From: Neil Whitton
Sent: 12 December 2019 10:39
To: Clare Whitehead
Cc: DC Support
Subject: 19/02550/F - Land West Of M40 Adj To A4095 Kirtlington Road Chesterton

Environmental Protection has the following response to this application as presented:

Drawing Number: BMD.19.010.DR.P104

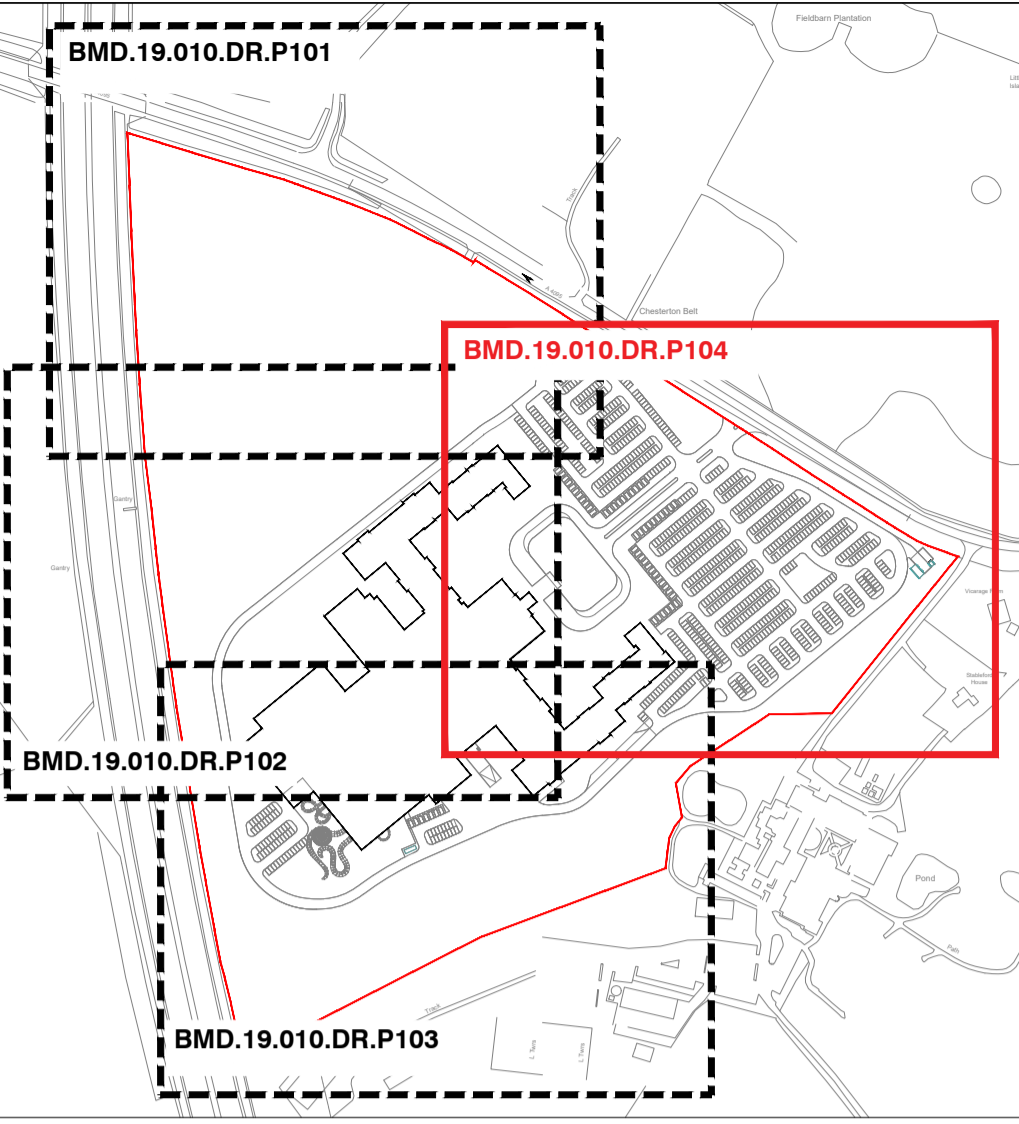
Noise from fixed mechanical plant at the boundary of the nearest residential locations (Vicarage Farm and Stableford House) should achieve the levels set out at table 8.12 in the noise report produced by WSP dated Nov 2019 provided as part of the application.
